CITY OF ALBUQUERQUE

September 3, 2021

**RE: 2 Alikhani, Naser – Home
1200 Hideaway Lane SE
Grading and Drainage Plan
Engineer's Stamp Date: 08/17/21
Hydrology File: M23D017A**

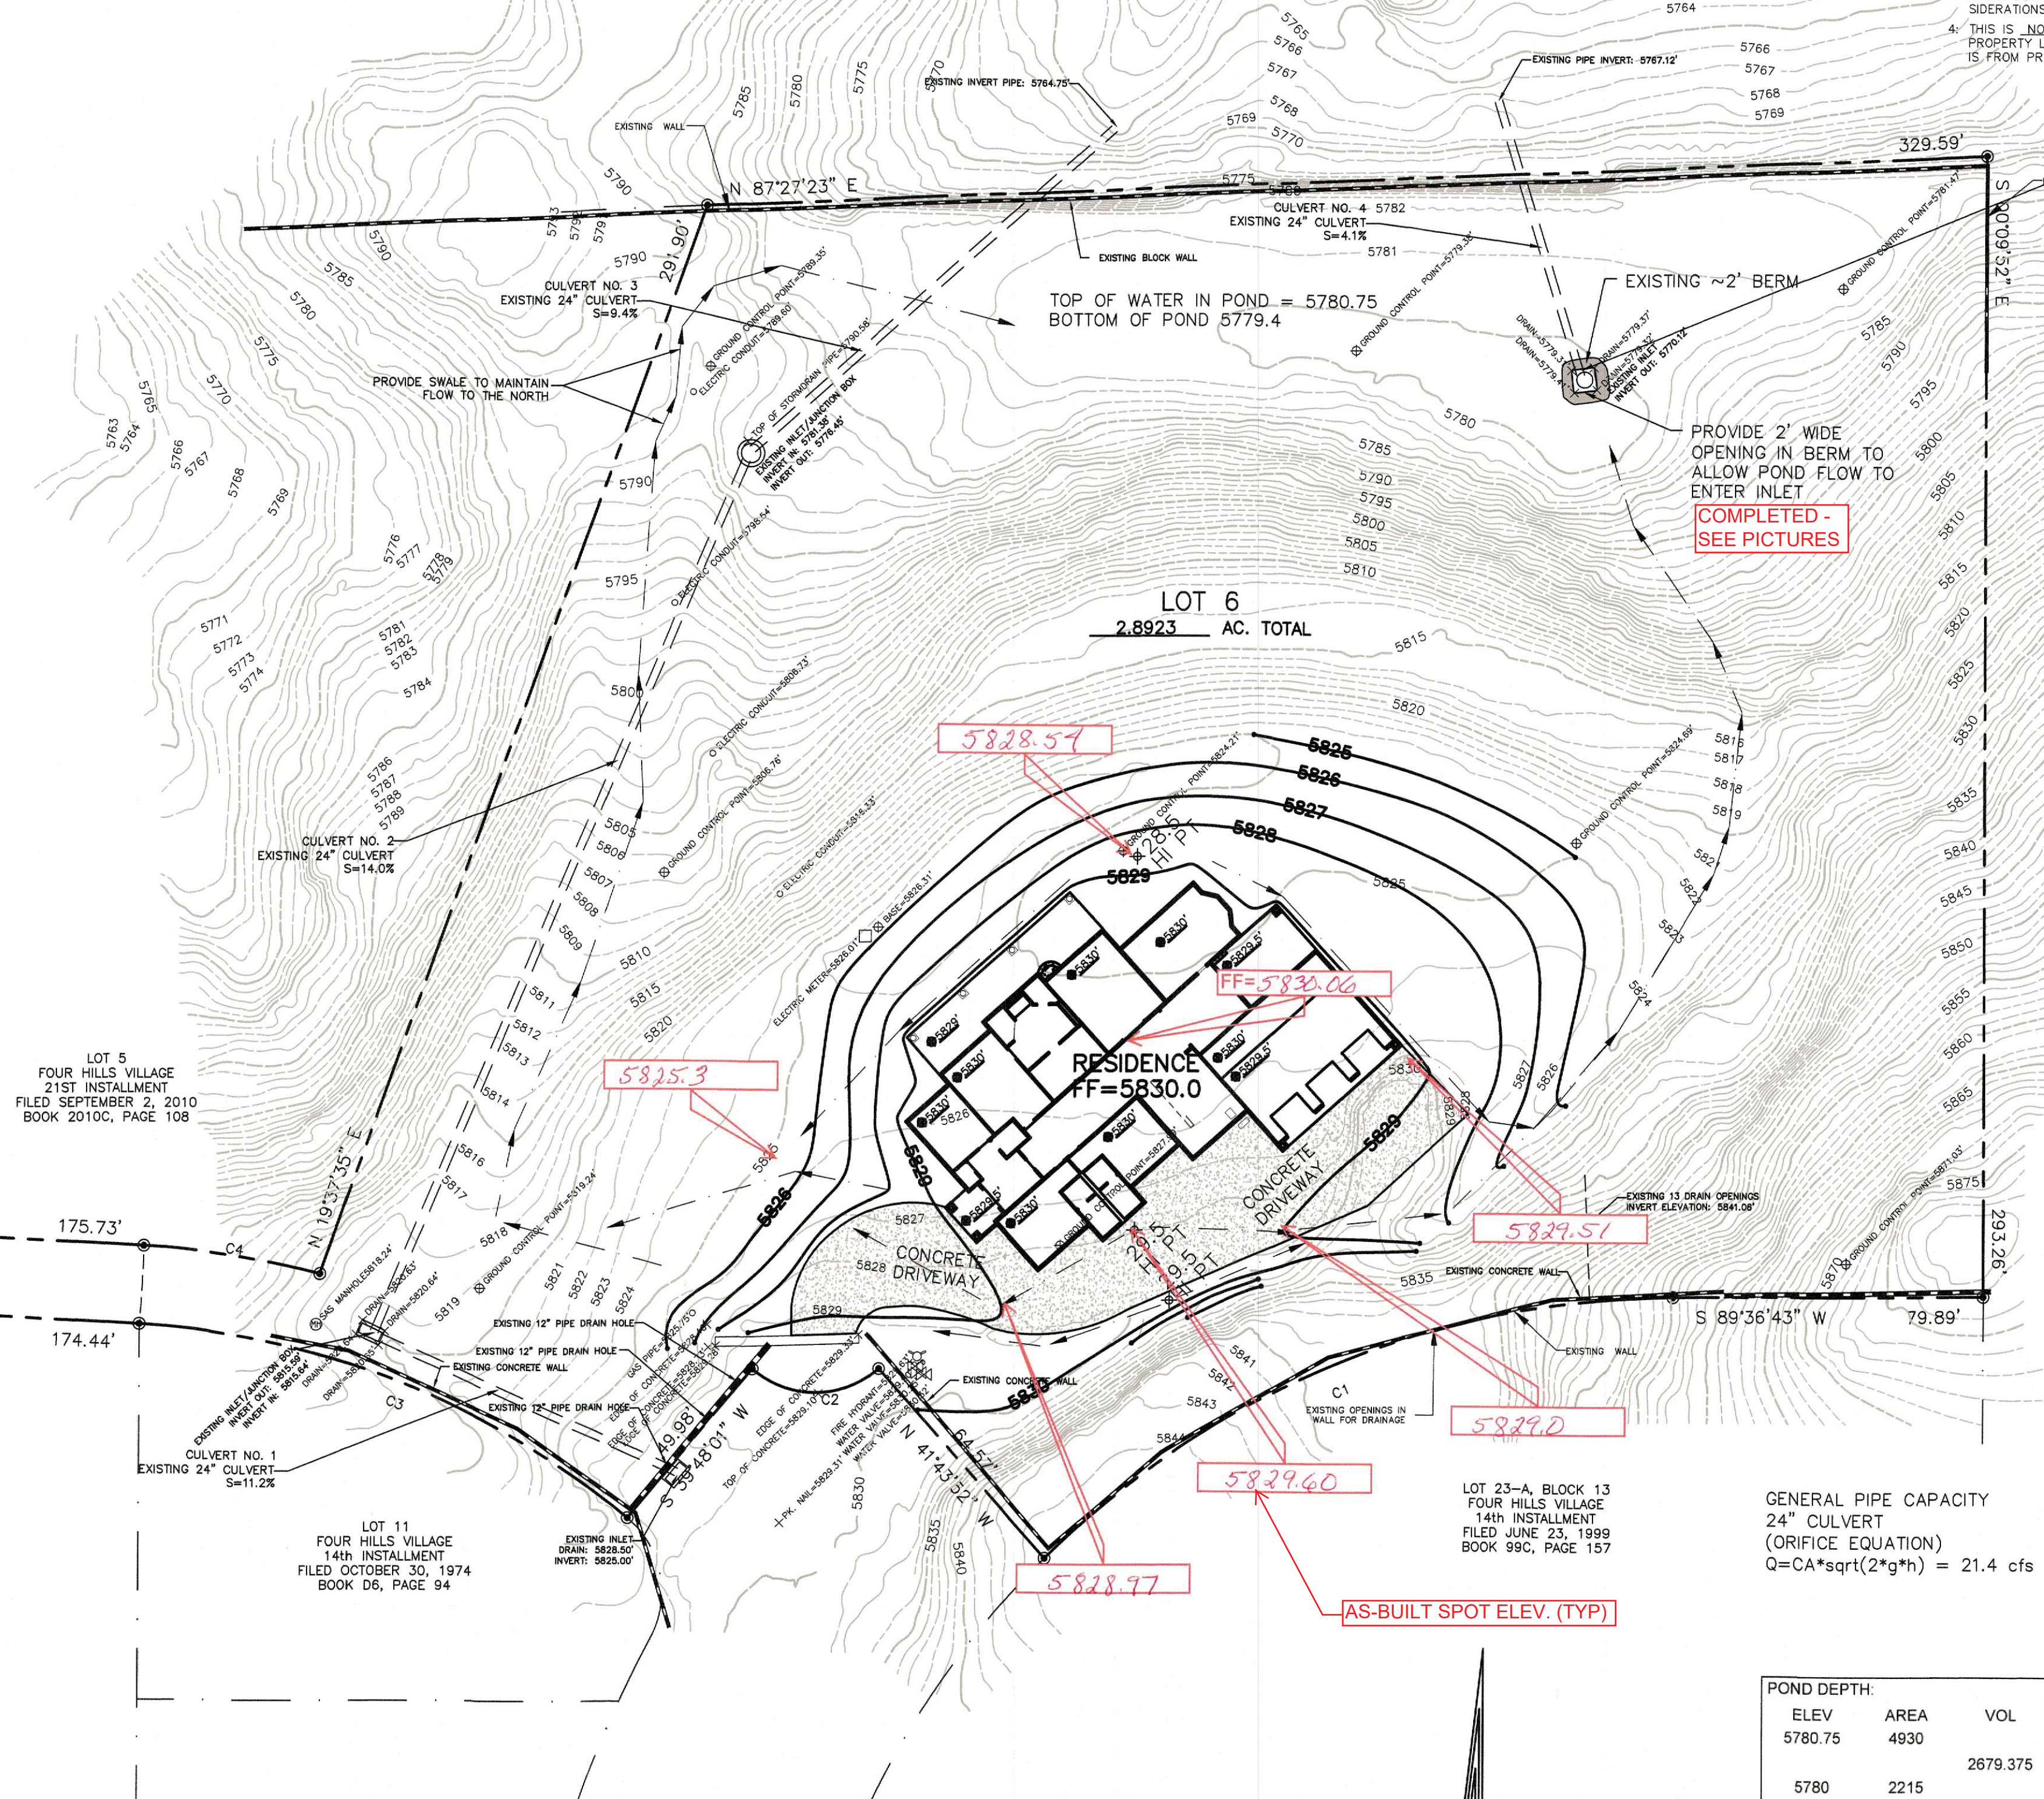
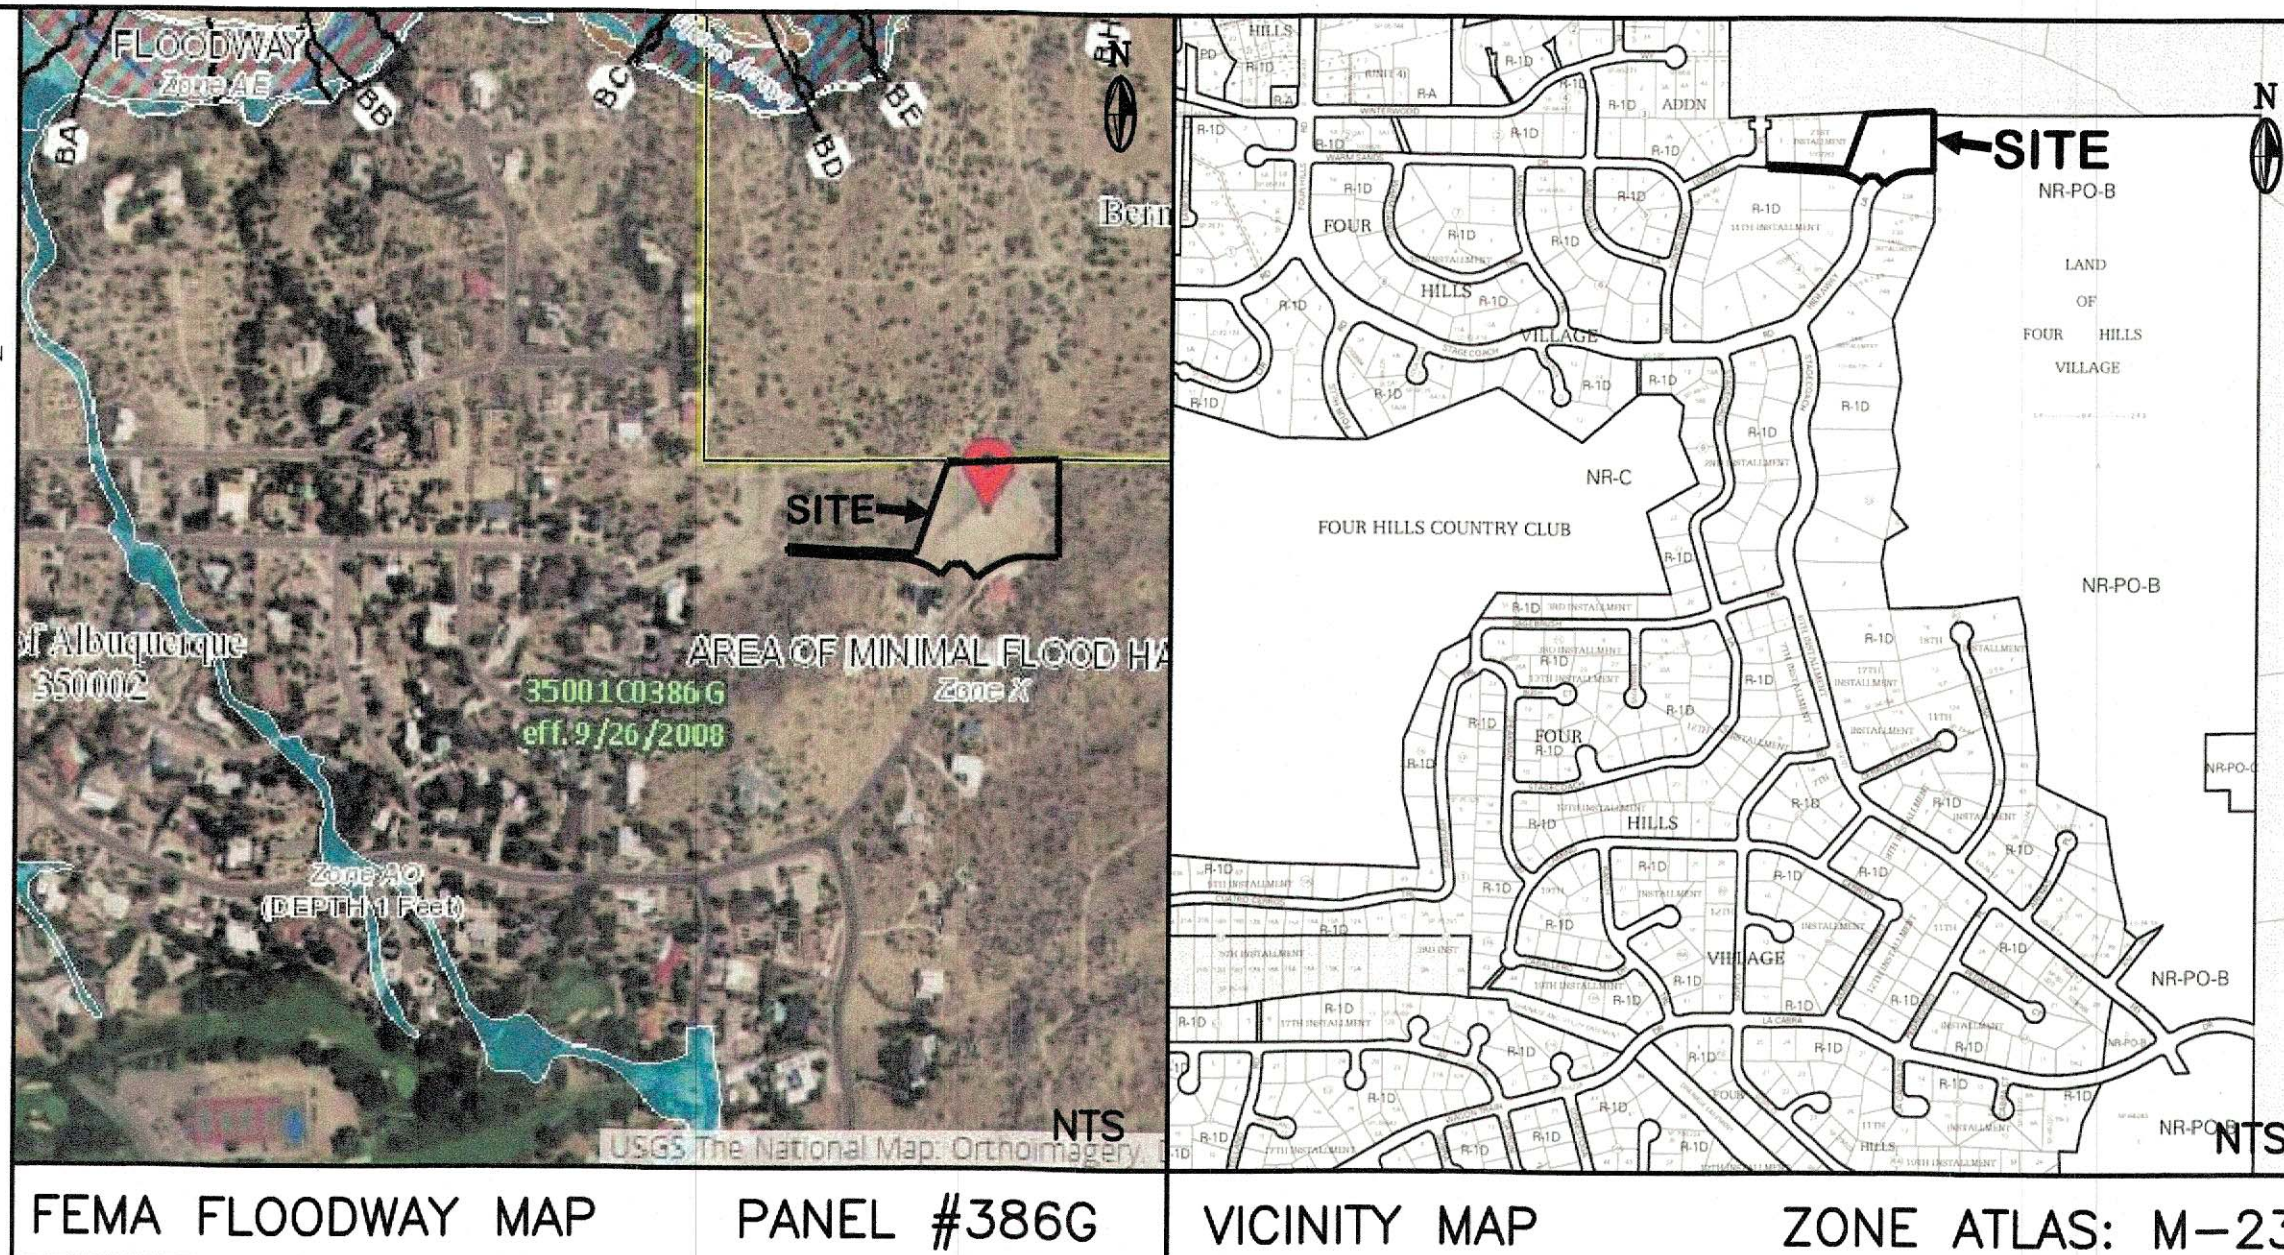
1. This lot is part of the Drainage Report for Four Hills Village 21st Installment by Bohannon Huston dated May 22, 2009 (M23D017). This drainage report states that each lot is required to pond developed flow greater than existing flow, so for lot 6 the existing flows is **9.62 cfs** and the existing 24-in storm pipe from the pond you have calculated discharging 21.4 cfs which is **11.78 cfs** too much. This pond need to be a detention pond that hold back the **11.78 cfs** and you will need to design a solution for the outfall. Provide all calculation and designs in the next submittal.

2. Please size a detention pond as outlined in the approved Drainage Report and the existing pond that exists may have to be filled in.
3. According to the recorded plat for this subdivision, each lot Owner is required to provide an individual soils report from a Geotechnical Engineer for review and acceptance by the City of Albuquerque. This is very important since 2009 this lot Owner has been dumping earthwork onto this site so that the material currently there is not native to the site. This Geotechnical Report was claimed to be submitted with this submittal was not included. Please include this in the updated submittal.
